11 January 2016

Our Ref: KFOR 15/138

**Kings Forest MP08-0194 (MOD 3) – Proposed Service Station and Food & Drink Premises**  
**Within Precinct 1 – Response to Submissions**

Scale	Date	Job Number	
1:2500@A3	NOV 2015	738.12	
Drawn	Stage	Drawing No.	Issue
PN	DA	0000	E

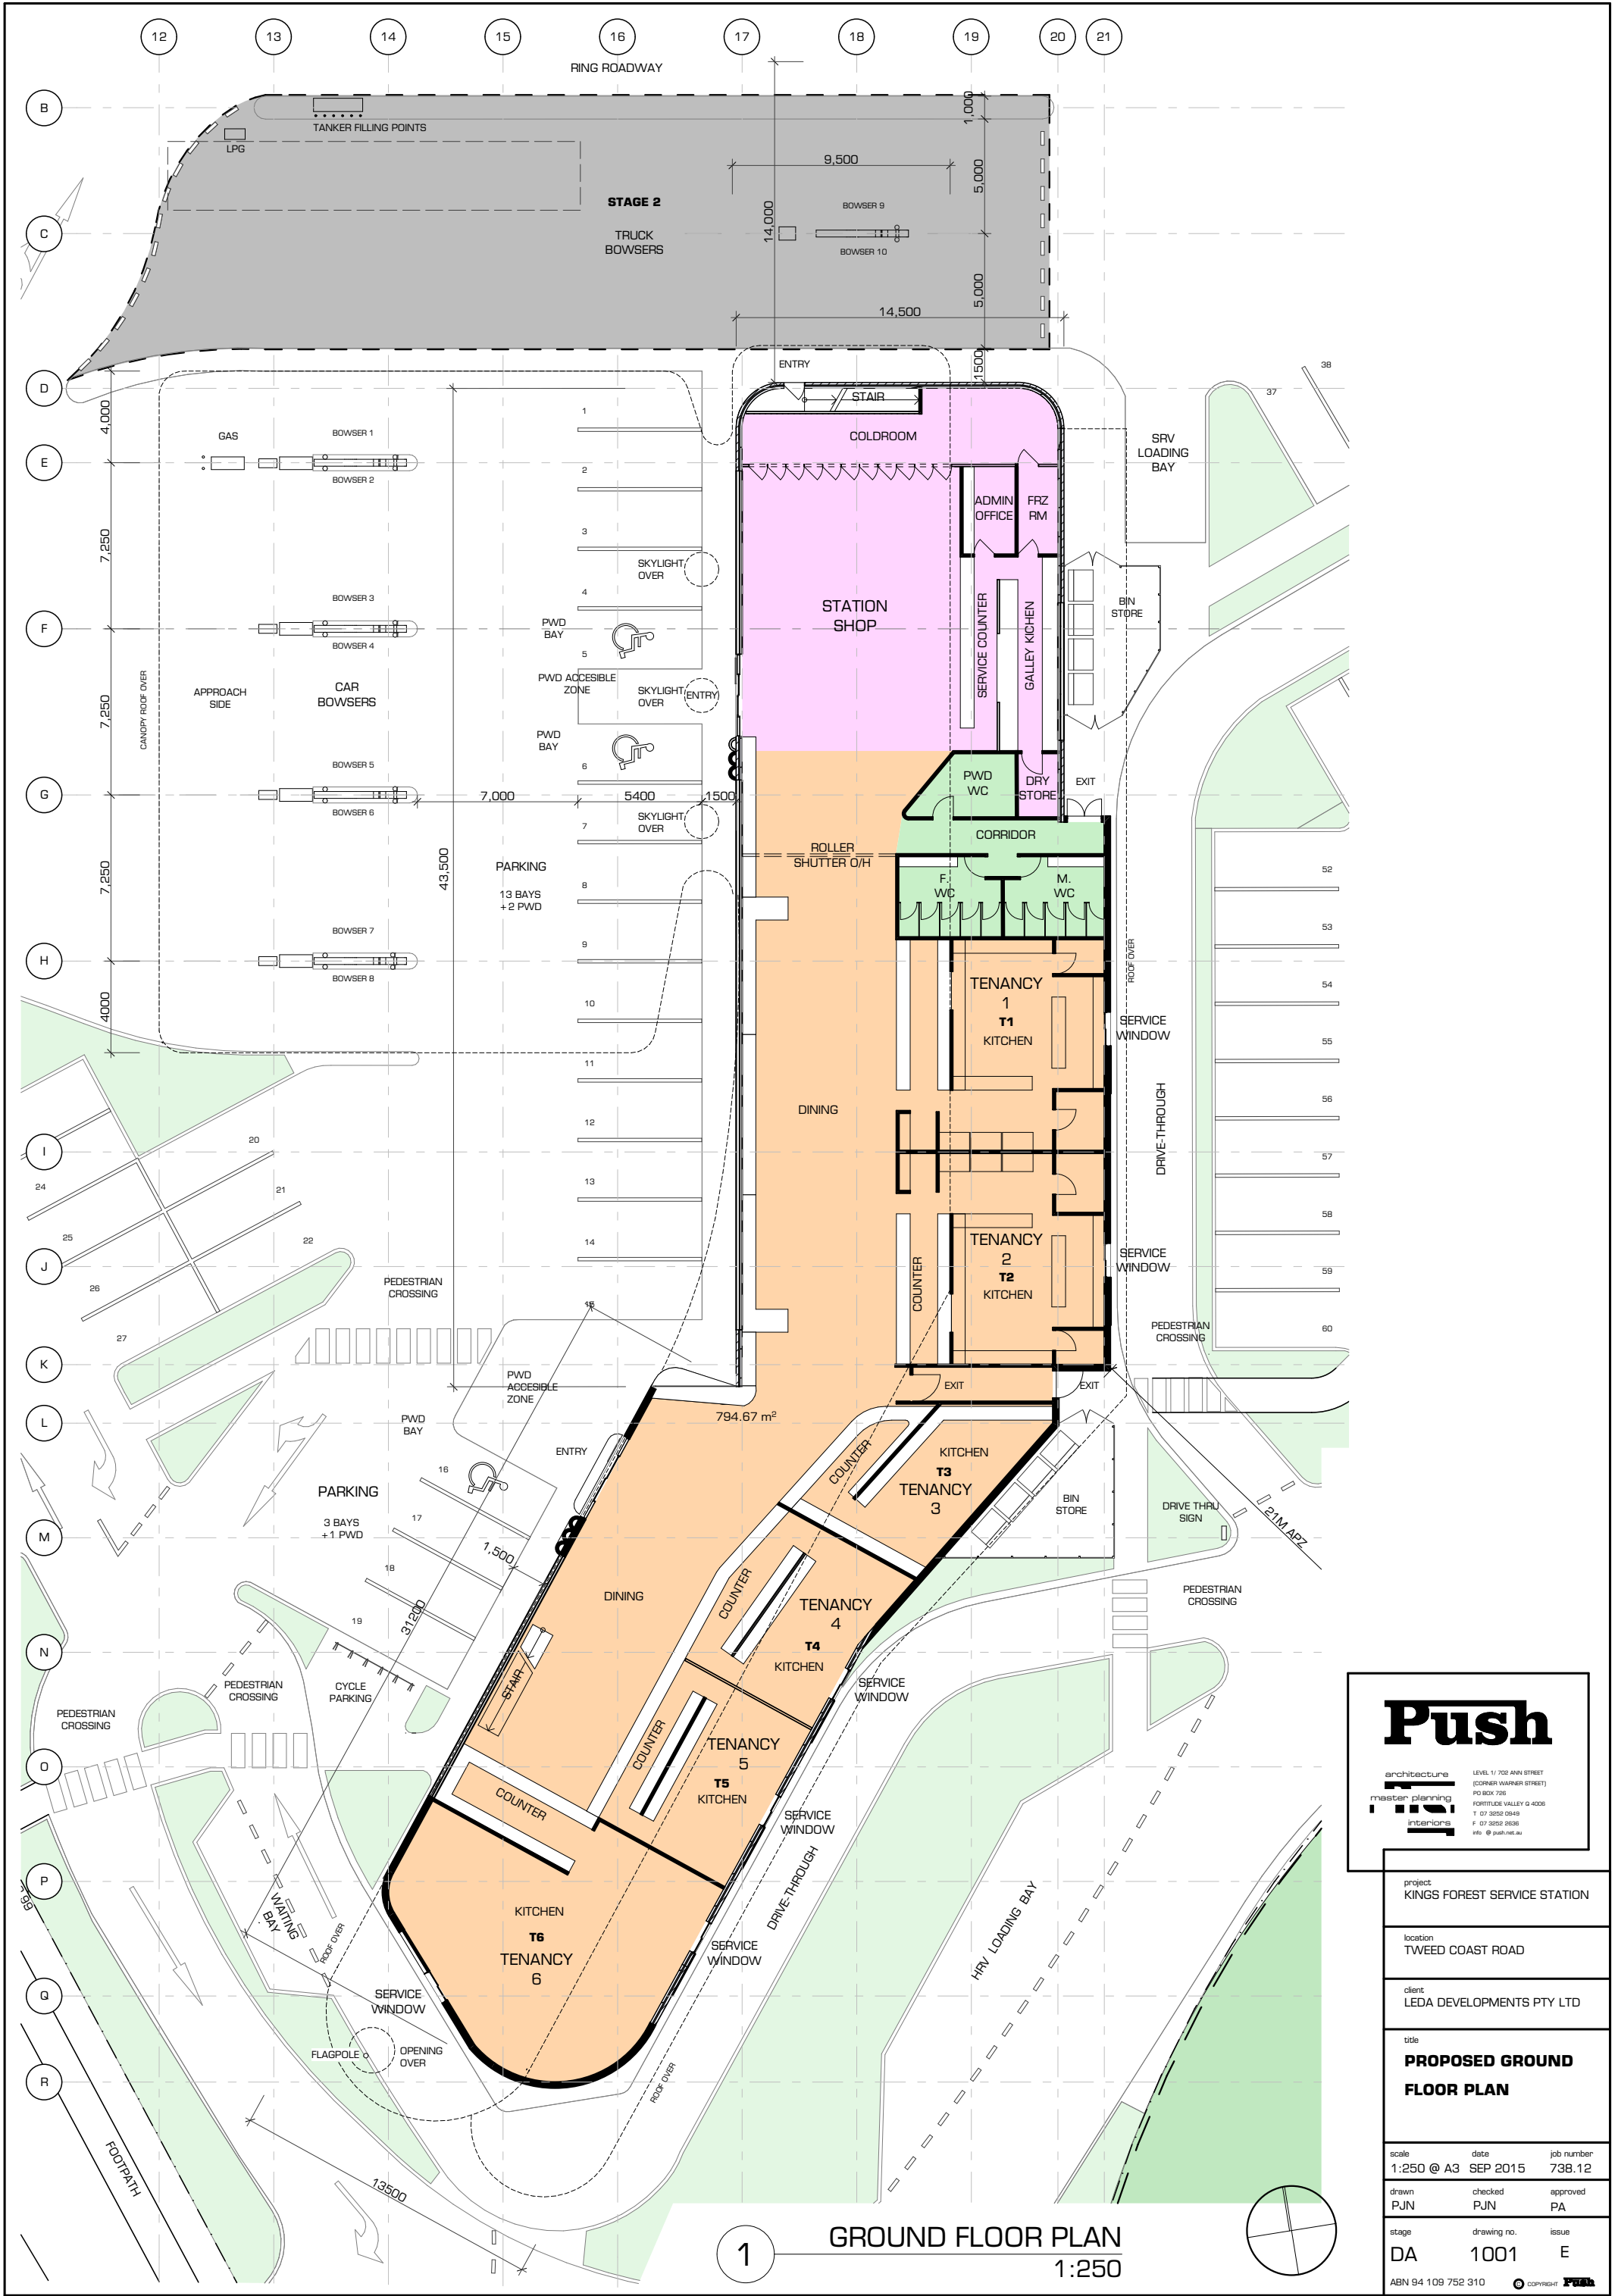
- *The proposed truck bowzers (stage 2) should be located a minimum 7 metres from the northern boundary and be designed to withstand 25 k/Wm<sup>2</sup> radiant heat exposure;*

The truck bowzers scale approximately 10m from the northern boundary of the site and therefore comply.

Scale	Date	Job Number	
1:250@A3	SEP 2015	738.12	
Drawn	Stage	Drawing No.	Issue
PN	DA	2002	D

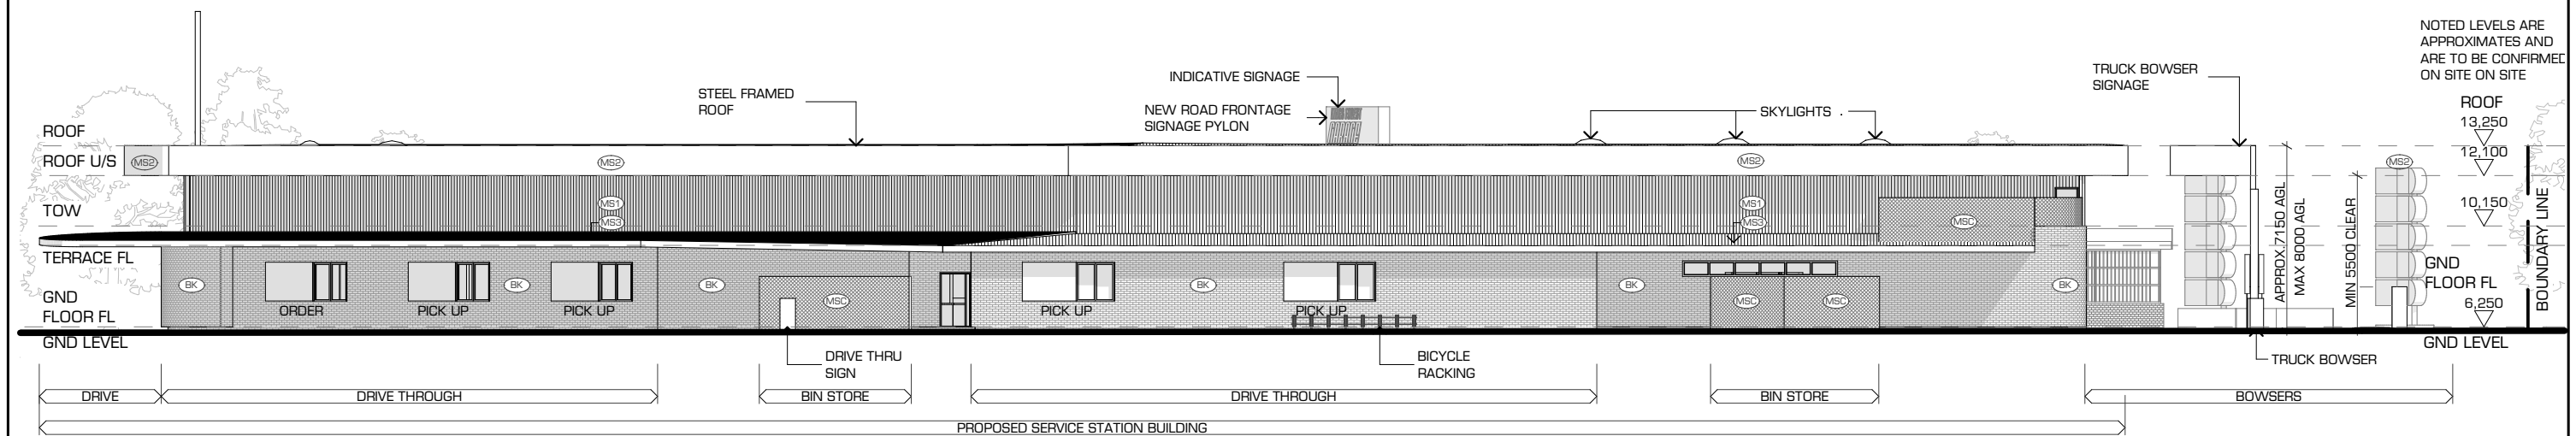
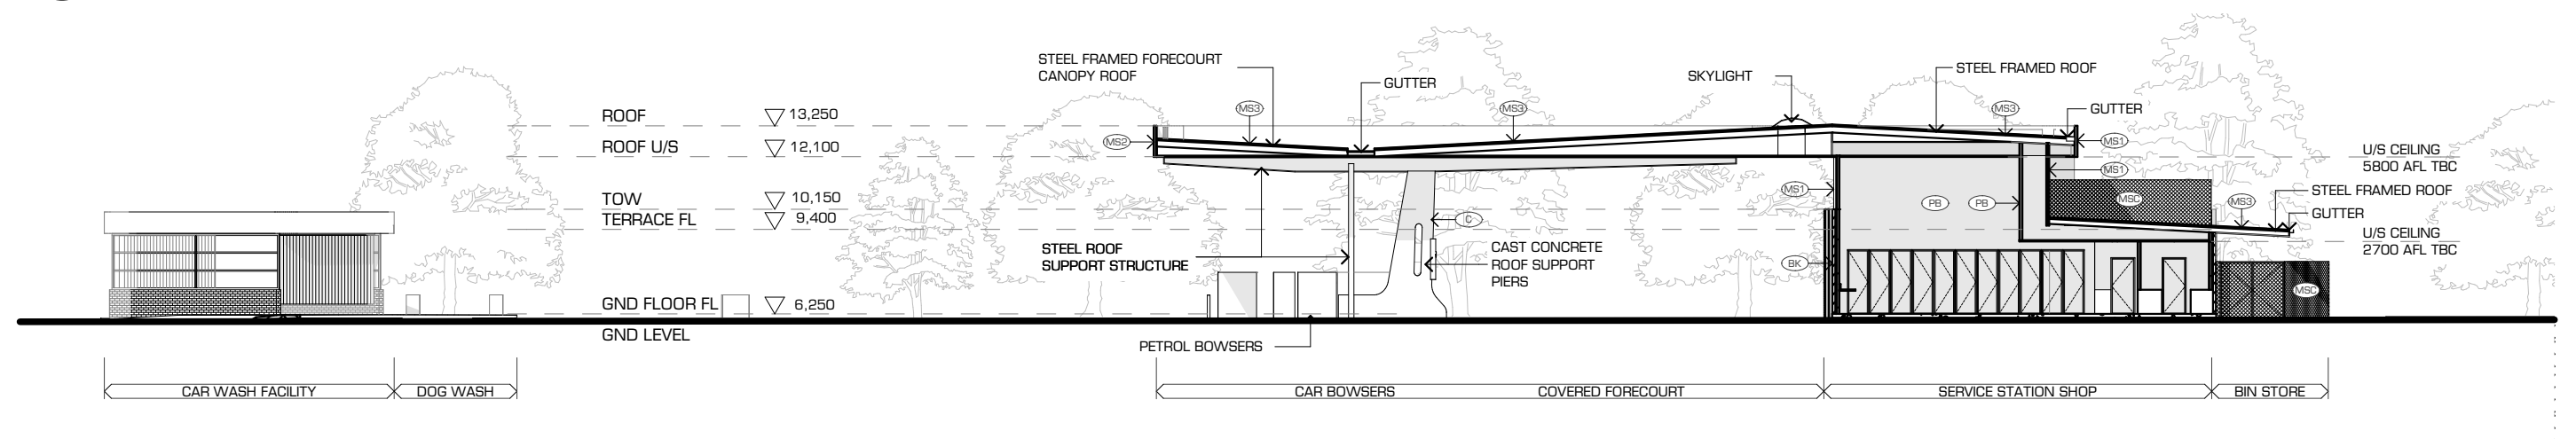
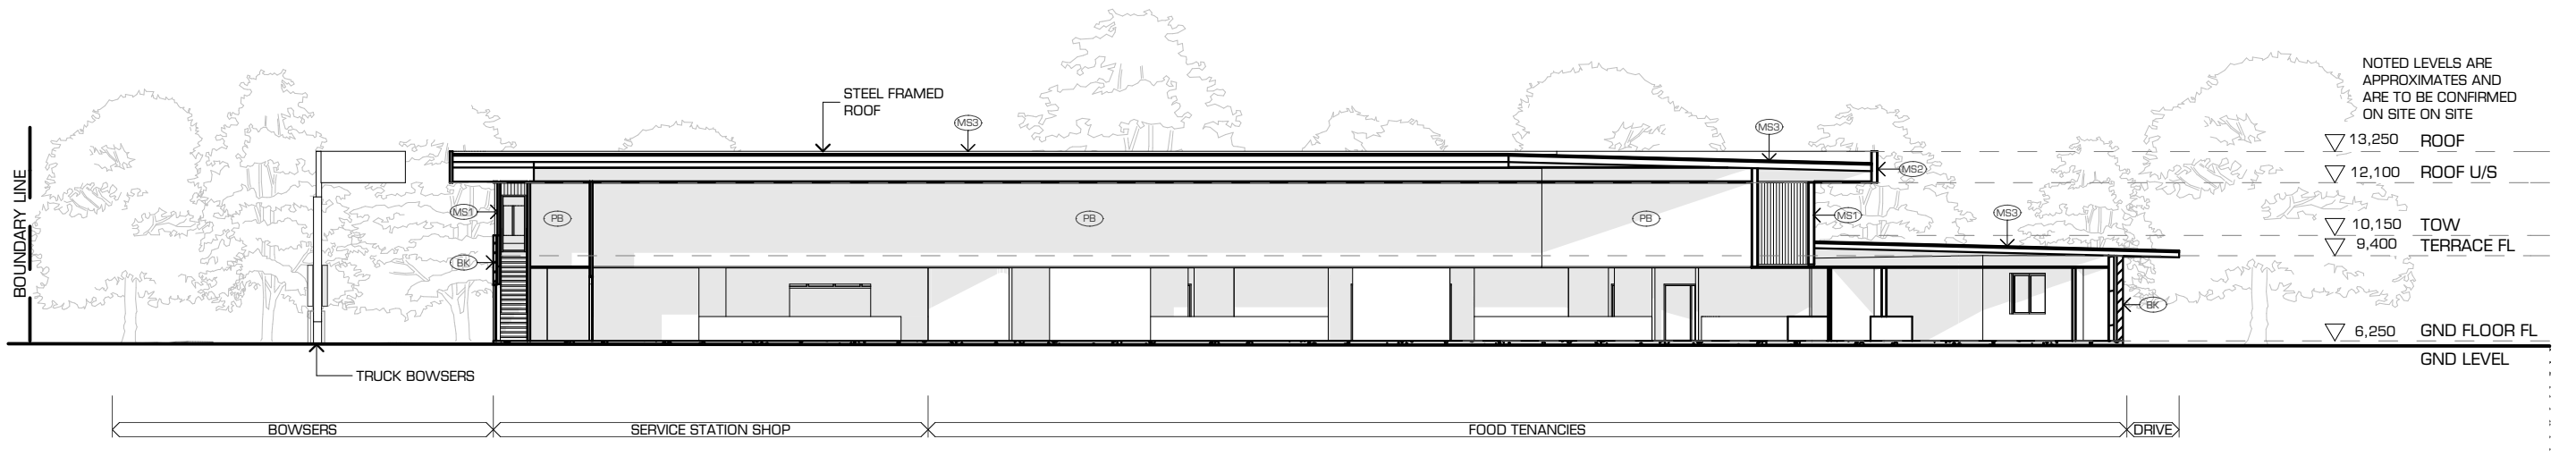
- *The northern and eastern elevations of the proposed Service Station building shall be constructed to the requirements of Sections 3 and 7 (BAL 29) Australian Standard AS3959-2009 'Construction of buildings in bush fire-prone areas' and section A3. 7 Addendum Appendix 3 of 'Planning for Bush Fire Protection';*

The Project Bushfire Consultant (Melanie Jackson – Bushfire Risk) has discussed this Condition with Mr Alan Bawden of the Rural Fire Service in relation to the service windows at the fast food outlets on the eastern wall of the building. On the basis that the building will be air conditioned, the services windows will be closed at all times when not in use to service drive through customers. Therefore the Department is requested to include provisions in this requirement varying the building design standards to remove the need for screening of openable windows.
